# Rezoning Transportation Analysis

Petition Number: 2022-197

Date	Description
3-22-23	First Review (TM)

RZ-1

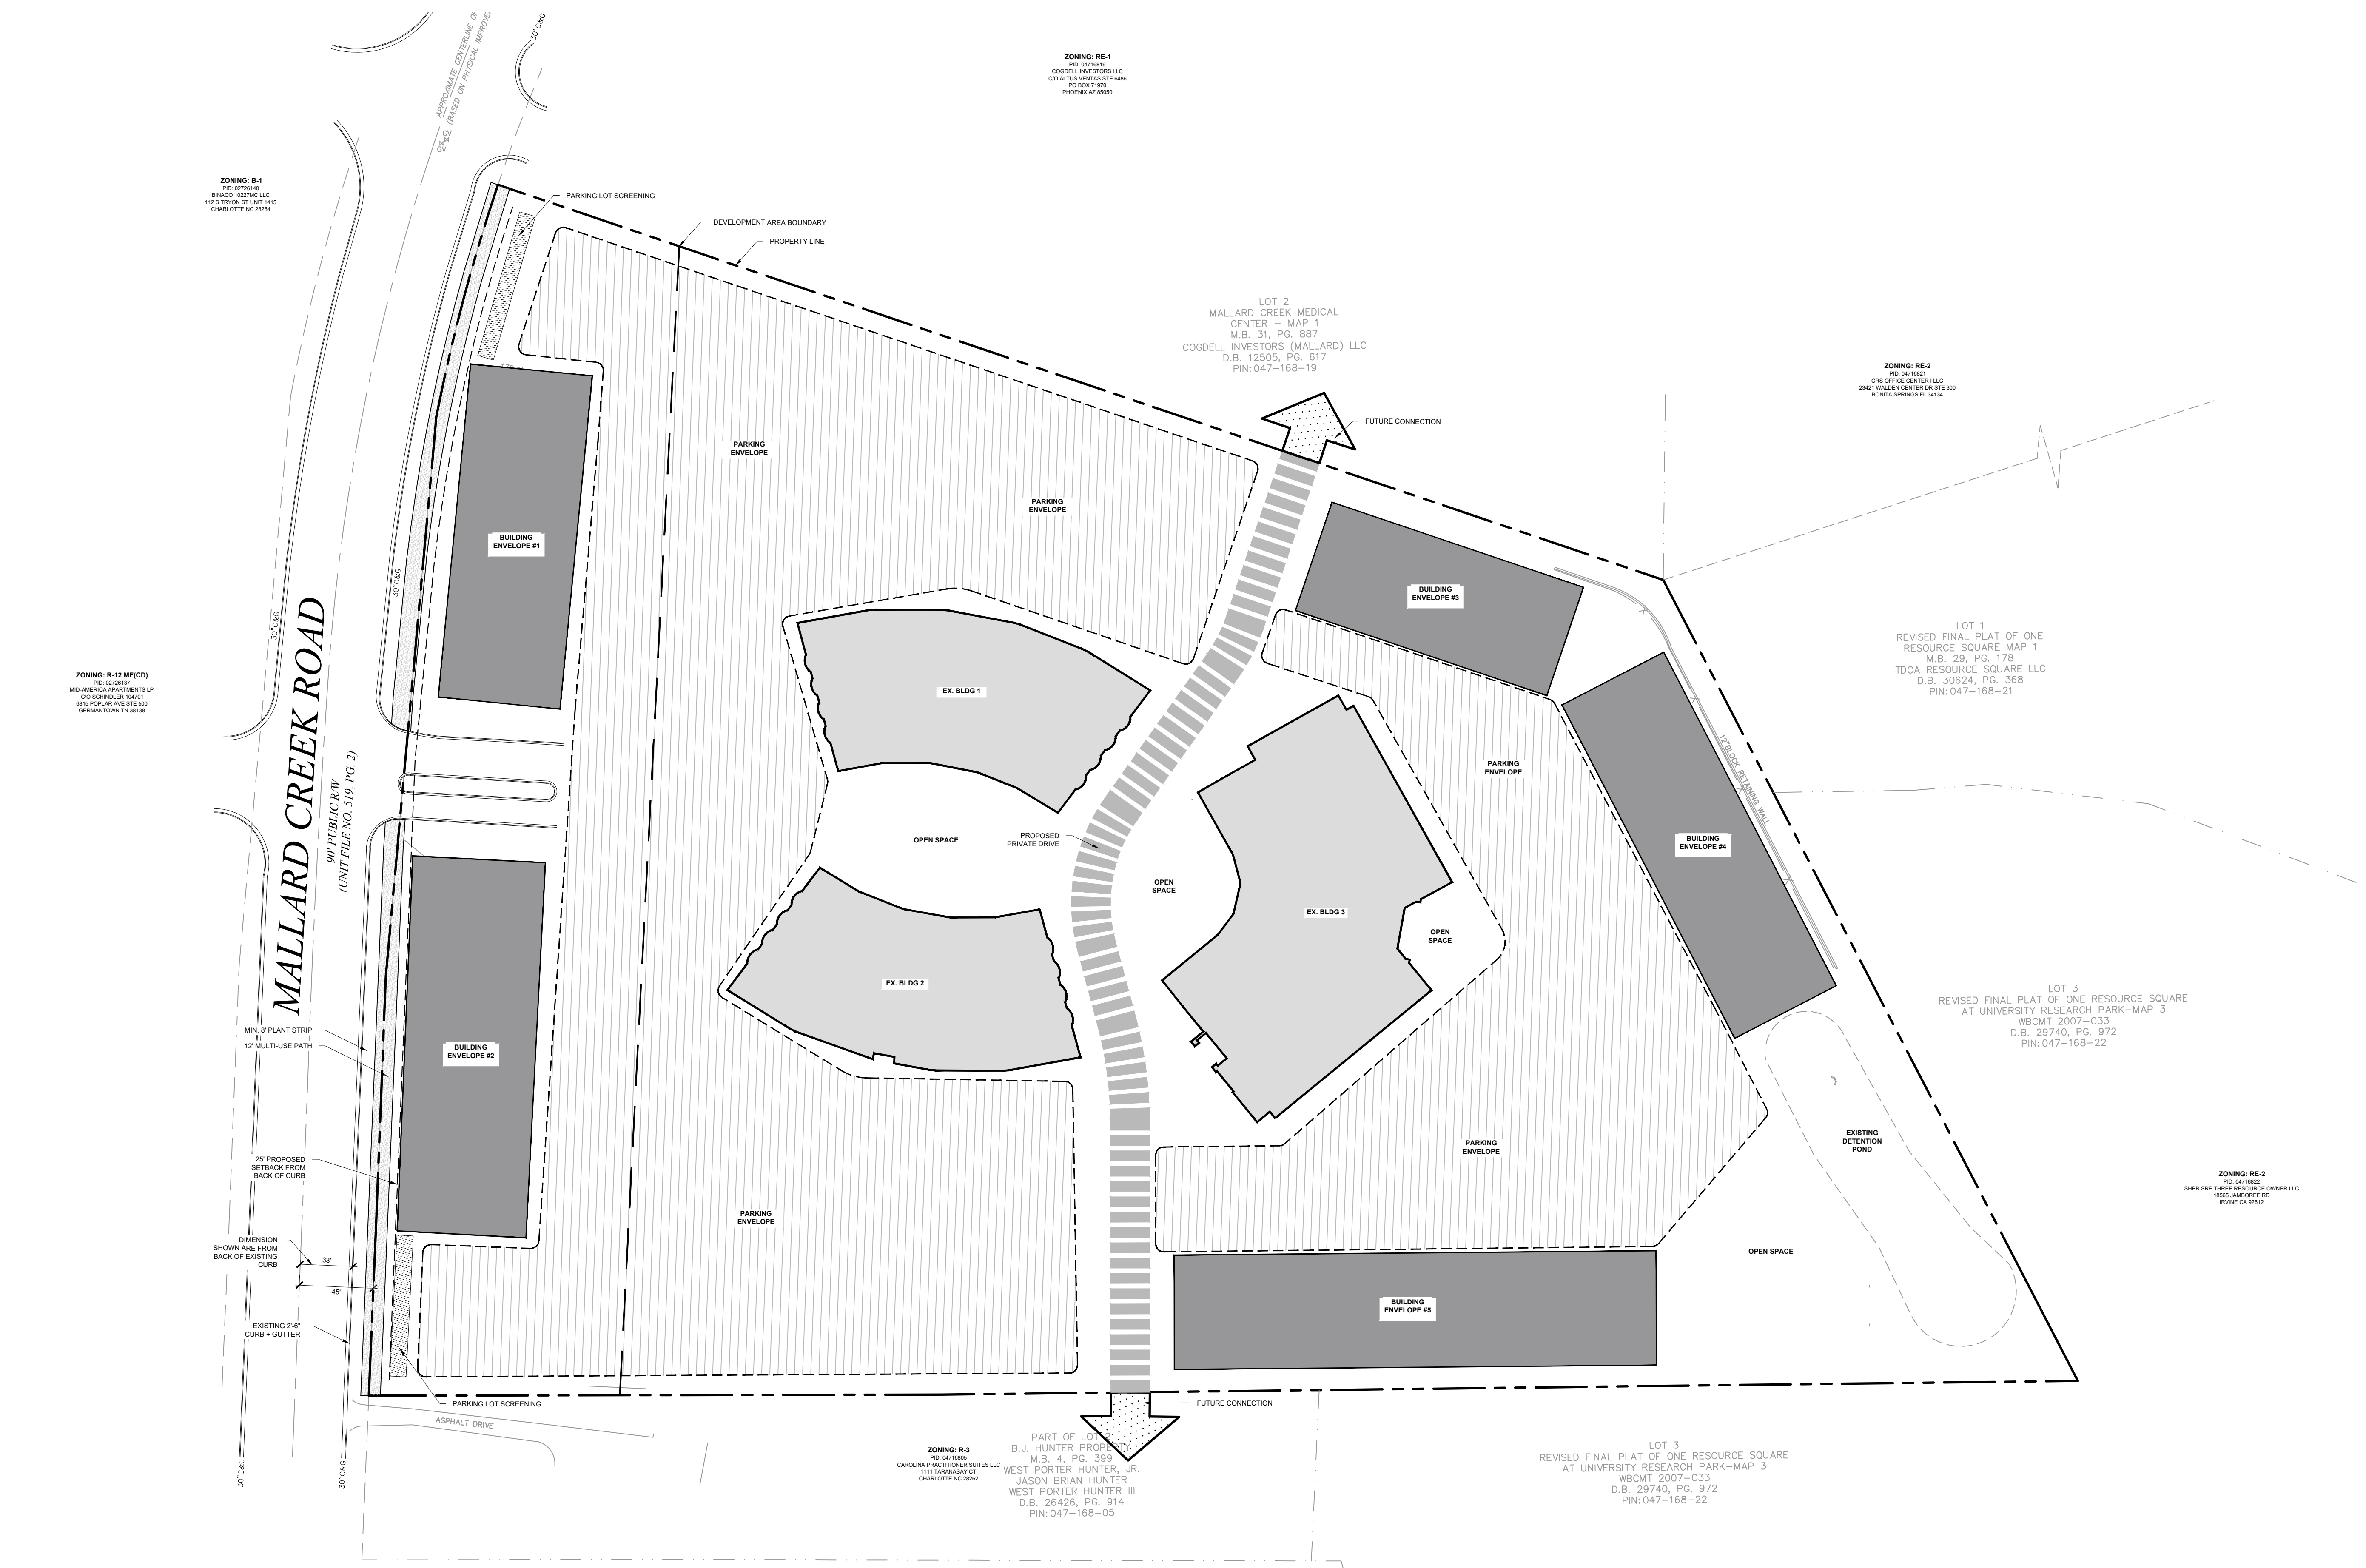
- a. **Mallard Creek Road:** The future location of curb and gutter is in its existing location.

Label and dimension the curb and gutter from the centerline for each road on the site plan.

- 3. Revise site plan and conditional note(s) to commit to dedicate 50-feet of right-of-way from the road centerline. The site plan shall label and dimension the right-of-way from the road centerline.
- 4. Revise site plan and conditional notes to commit to installing a dedicated right turn lane on Mallard Creek Road per NCDOT coordination. Site plan shall label and dimension the turn lane. Add a conditional note that details this turn lane improvement.
- 5. Revise site plan and conditional notes to clarify the future connections shown on the site plan.
